Planning Application 2024/62/92444/E – Land North of Denby Lane, Denby Lane, Grange Moor, Huddersfield, WF4 4BH (Erection of 21 dwellings and associated works with means of access from Denby Lane)

I refer to my previous correspondence dated 26 November 2024 and 13 February 2025 with respect to the above. I note the recent submission of a revised layout plan reference “Site Plan Rev U” and would add the following comments to those already set out in my earlier letters.

### Proposed Site Plan

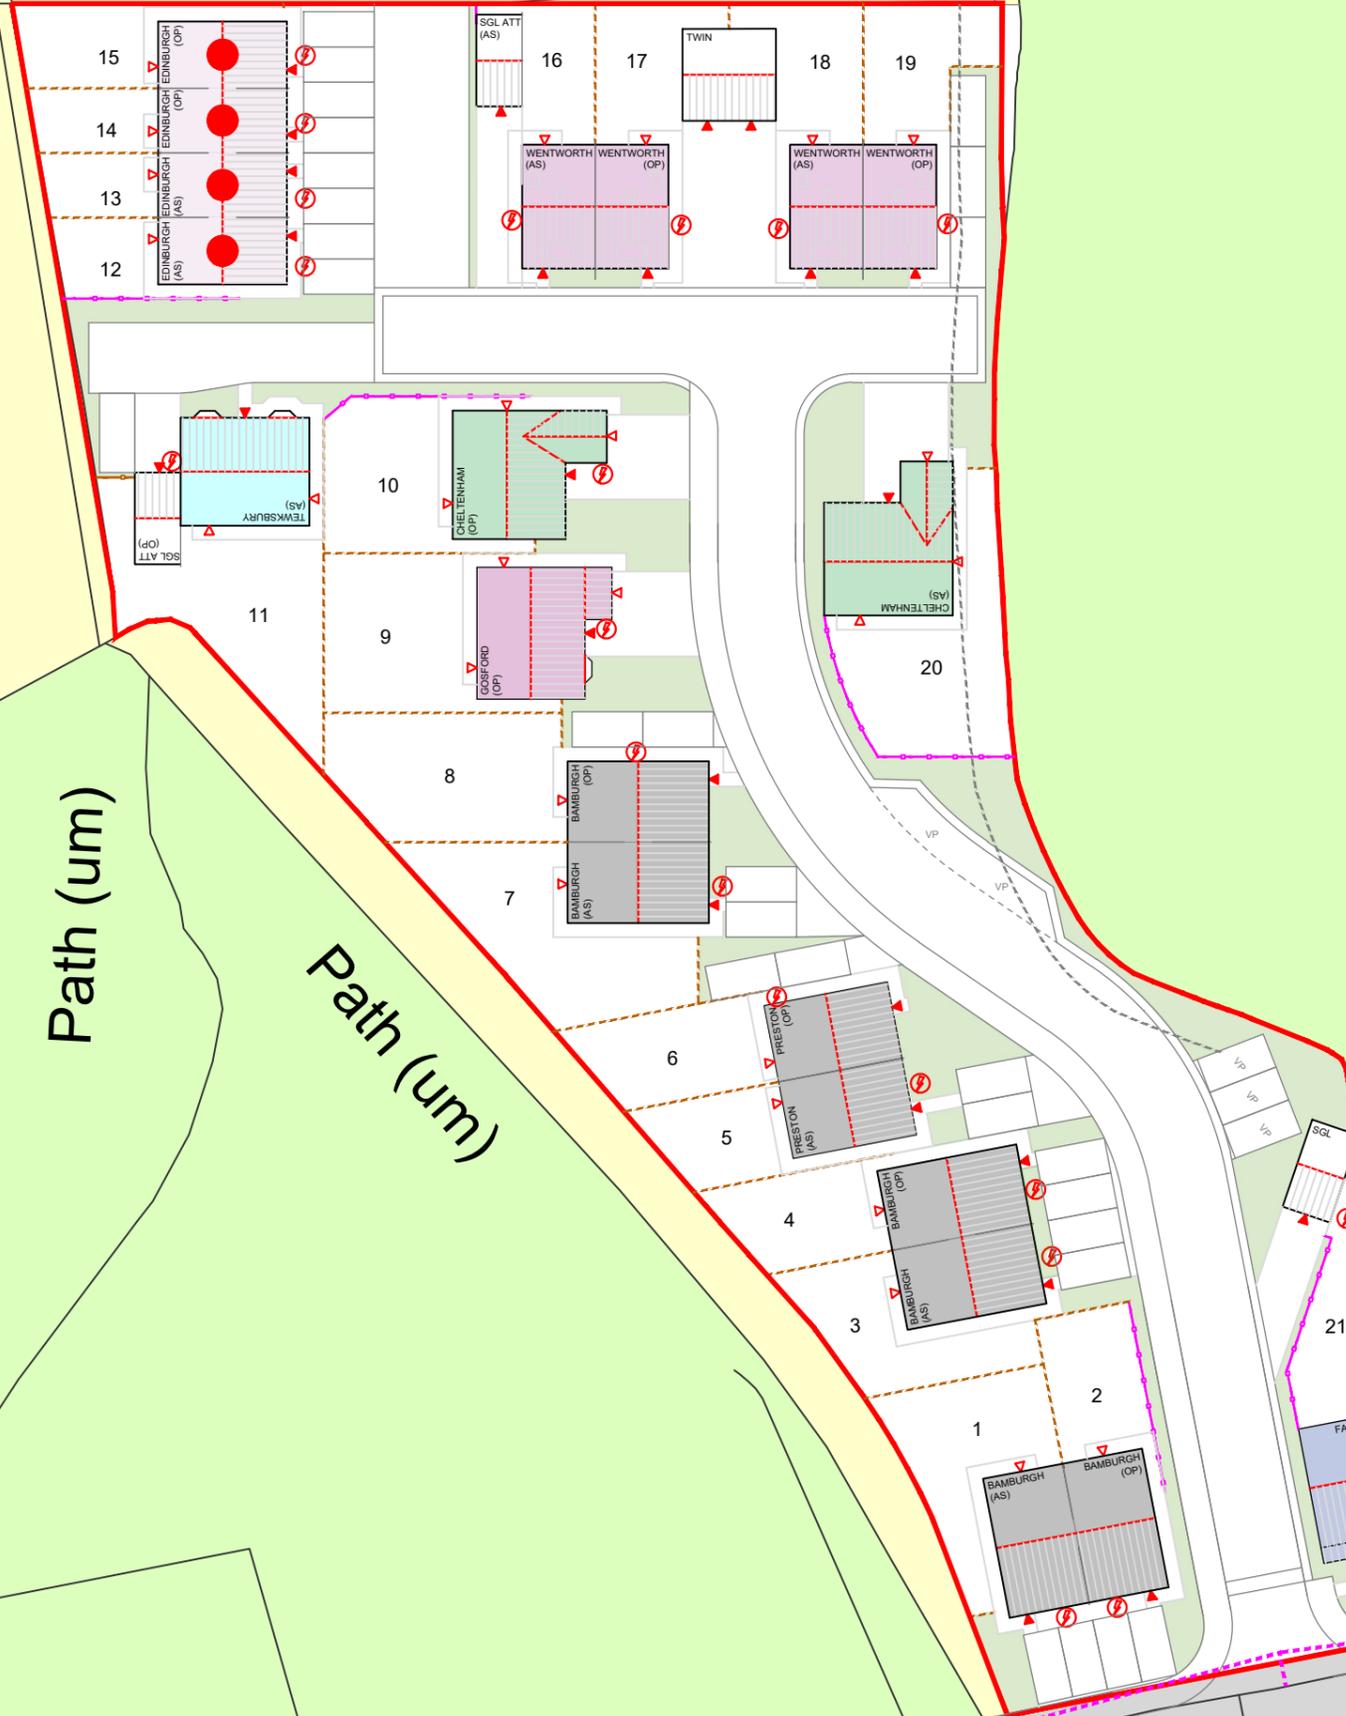
To comply with the requirements of the Council’s Tree Preservation Officer, the dwelling on plot 21 has now been set back from the site boundary with my land. This is to minimise any conflict between existing trees, which I assume are to be safeguarded, and the proposed dwelling. Plots 1 and 2 remain on the opposite hand of the proposed estate road junction and appear to retain the previous overall plot widths. To achieve the increased boundary clearance, it appears that the proposed estate road has been reduced in width or slightly realigned. What is now apparent from the extract of Plan Rev U below, is that the indicated centre line of the proposed estate road does not comply with the correct technical position of the sight line operating from the junction to Denby Lane.

The indicated sight line is not set out on the central axis of the junction and is more to the west. This has a knock-on effect on the impact of the sight line on my adjoining land and is a matter that I have consistently brought to your attention throughout my correspondence on both this and the previous application for development of this site.

It is therefore important that this point is reviewed, and the sight line correctly imposed to demonstrate that the correct level of vision can be achieved without third party land. In addition, a revised series of vehicle swept path analysis are required to show that the amended junction operates correctly for vehicle movements in all directions.

Regarding the area shown between plot 20 and 21, indicated in the plan extract below; I would be grateful to know if this green area is to be adopted by the Council as public open space or is to be transferred to the future owners of the adjoining plots? Also, if responsibility for the proposed site boundary to this space is to be upon the Council or plot owners.
